Project: Waterloo Over Station Development (Southern Precinct) **Project No:** 46198
To: Patrick Garland **Date:** 5 February 2020
From: Brandon Notaras

RE: Response to Submissions – City of Sydney – Items 29 - 33

The purpose of this technical memorandum is to respond to the City of Sydney comments on the SSD DA submission for SSD-10437 (Southern Precinct). Specifically, this memo responds to items 29 to 33 of the City of Sydney submission.

15.2 Appendix 2 – Airborne Noise Modelling

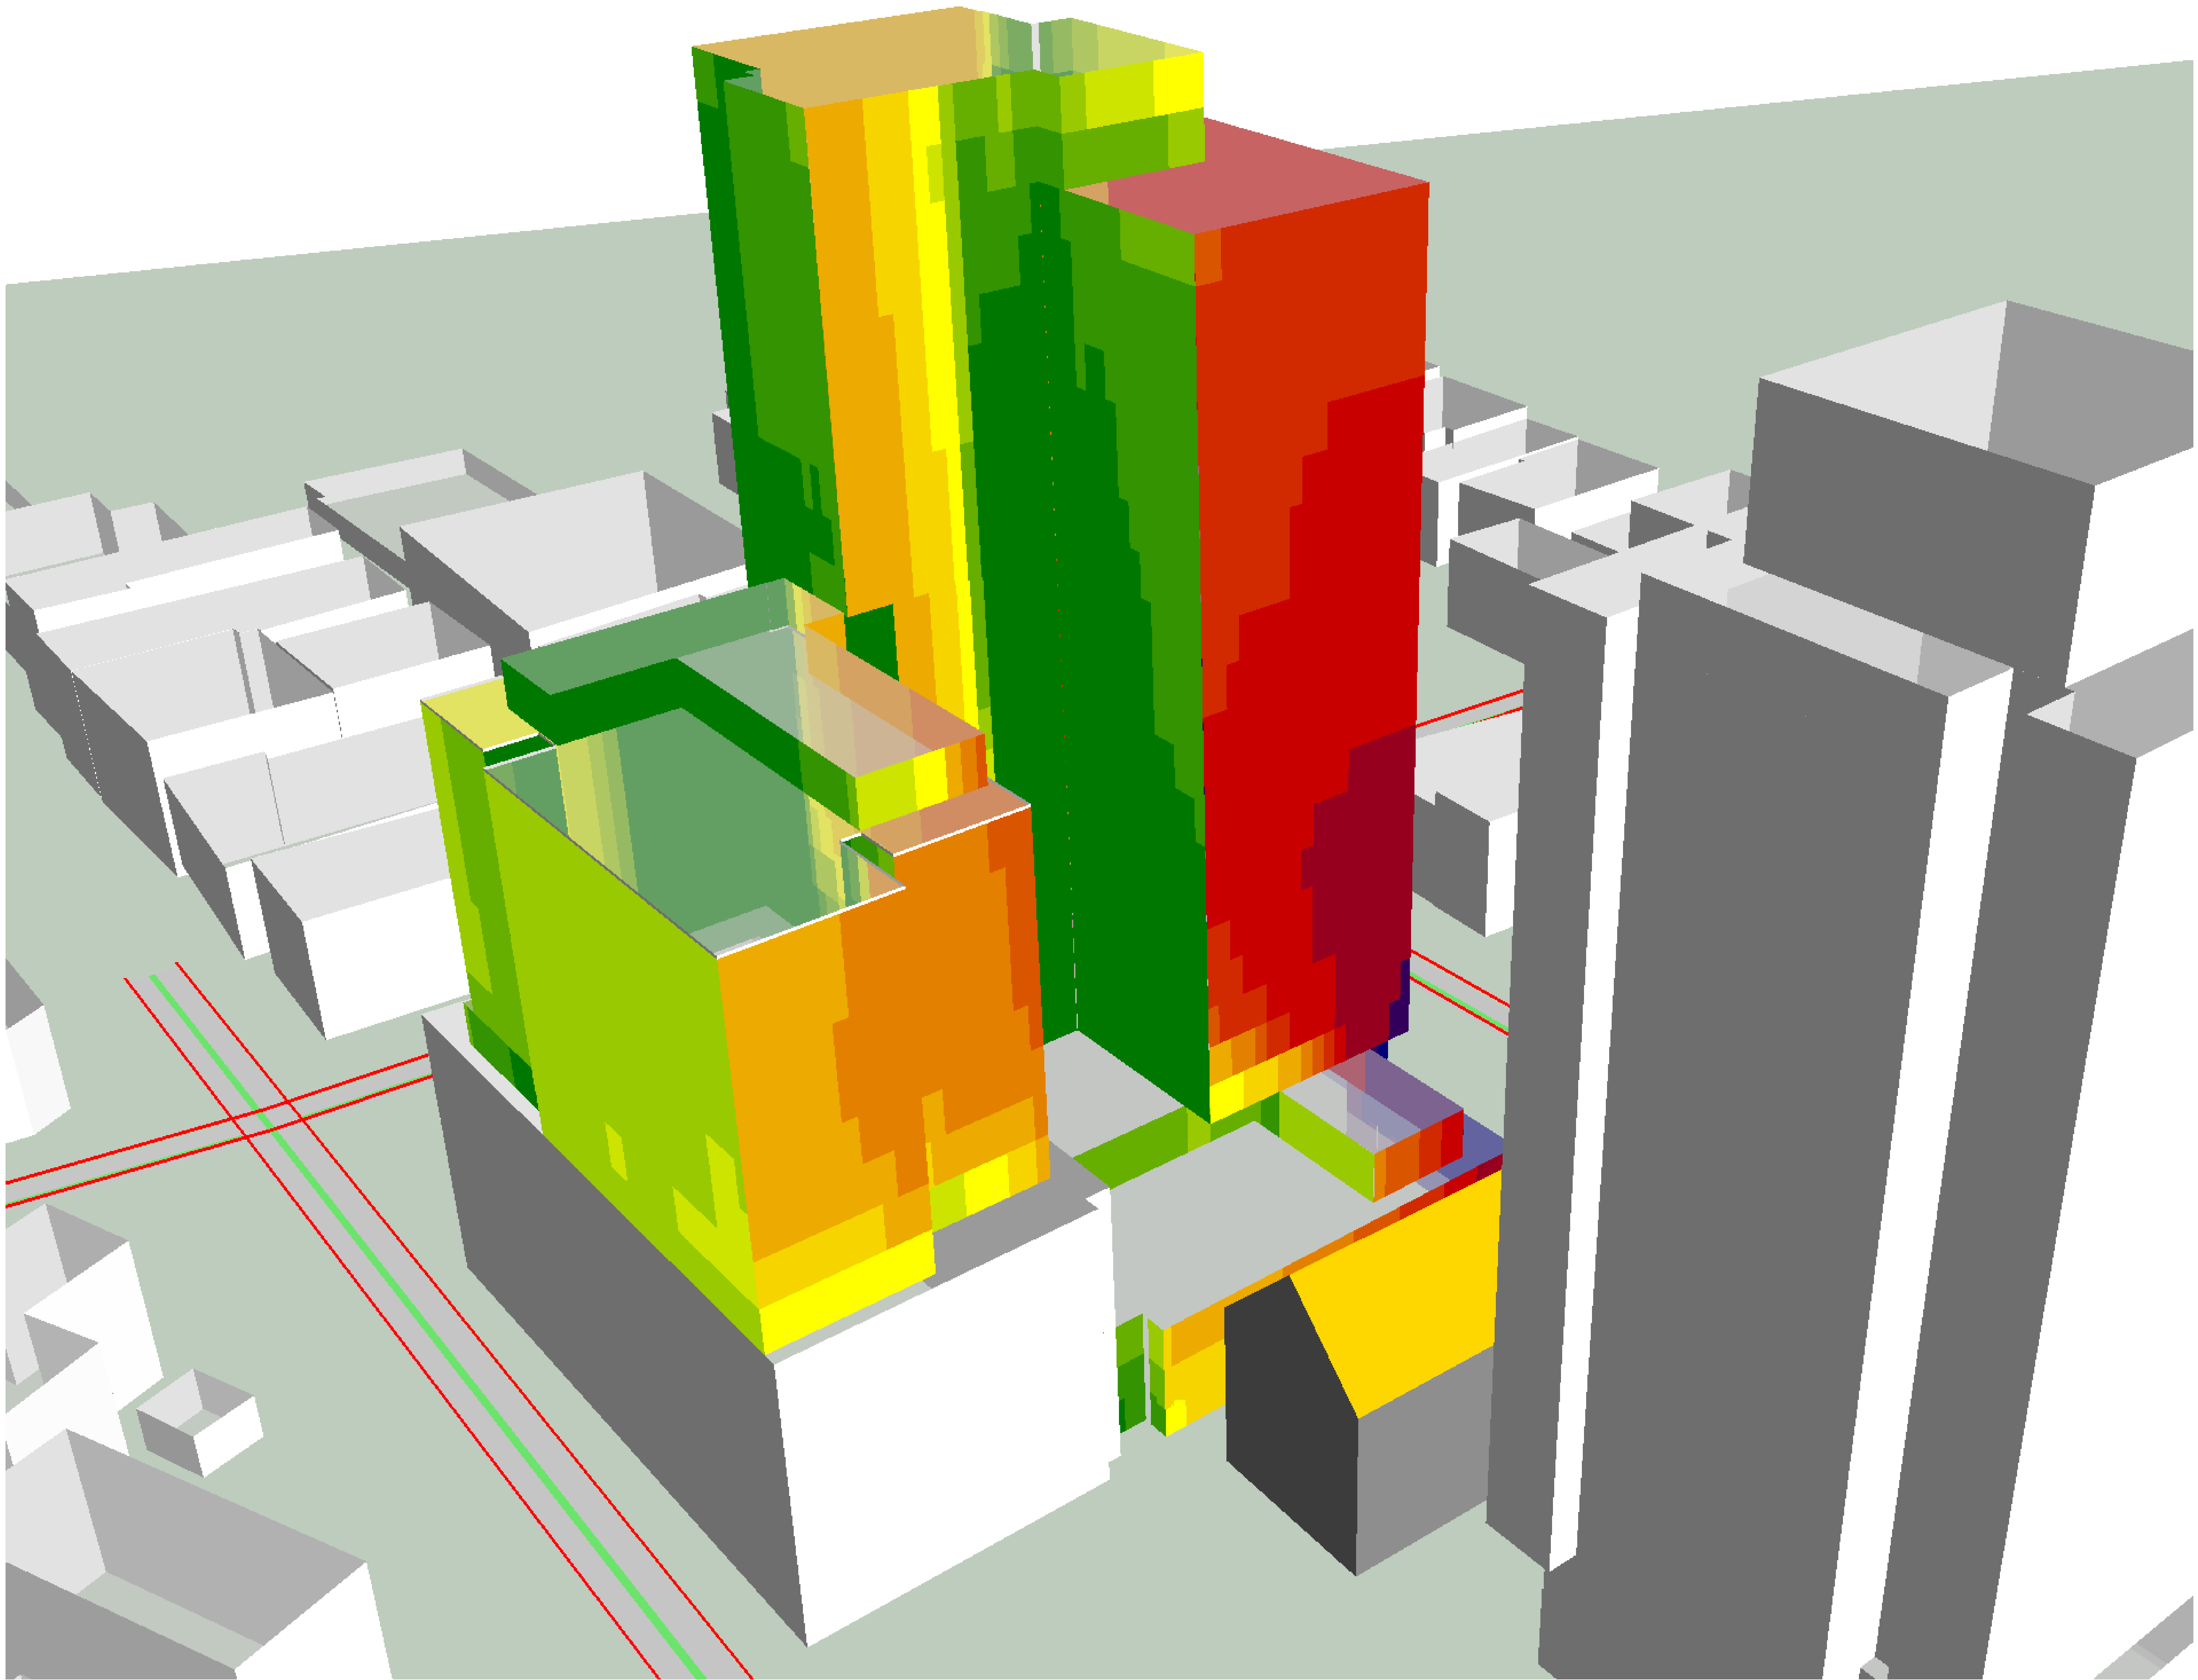
30	<p>City staff are concerned that the acoustic report has not sufficiently assessed the performance of the building to mitigate road noise, and the application has not adequately demonstrated compliance with Clause 102 of the State Environmental Planning Policy (Infrastructure) (ISEPP).</p>	<p>Road noise from Botany Road has been measured both before and during COVID-19. The monitor on Botany Rd was installed in a location similar to that of SLR’s monitoring location for the Concept SSD DA. Comparing the $L_{Aeq,15h}$ (day) and $L_{Aeq,9h}$ (night) noise data from both periods, the traffic noise emissions measured during COVID-19 are 1 dB(A) larger and 2 dB(A) smaller than that prior to, respectively. Given this conclusion, the higher of the two noise levels for each period was used to calibrate the road noise emissions model for Botany Rd. Extensive noise monitoring studies were conducted to carefully quantify the magnitude of noise emissions from Botany Rd.</p>	<p>Noise monitoring data – Sections 8.1 & 8.2, Pages 29 – 40</p> <p>Road noise emissions model – Section 10.2.1 and Page 64</p> <p>Road noise emissions results – Section 15.2</p> <p>Acoustic performance of building elements – Section 12.1 and Pages 93 & 94</p>

<p>The noise emissions model used to calculate the incident noise levels on the façade of Building 2 was created within SoundPLAN, a model recognized by DPIE for use for projects of this scale and complexity. The modelling provided the incident noise levels on the façade for use when calculating the resultant internal noise level within the space, applying the transmission loss associated with the components making up the building envelope (glass, solid wall, etc.)</p> <p>The required acoustic performance of the two types of elements making up the building envelope has been provided to demonstrate compliance with Clause 102 of the ISEPP 2007, showing the development will comply with the noise criteria applied to bedrooms and anywhere else within the development, which is:</p> <ul style="list-style-type: none"> (a) in any bedroom in the residential accommodation—35 dB(A) at any time between 10 pm and 7 am, (b) anywhere else in the residential accommodation (other than a garage, kitchen, bathroom or hallway)—40 dB(A) at any time. <p>Compliance with the requirements of this clause has been stated, so long as the acoustic performances outlined in the report are implemented.</p>
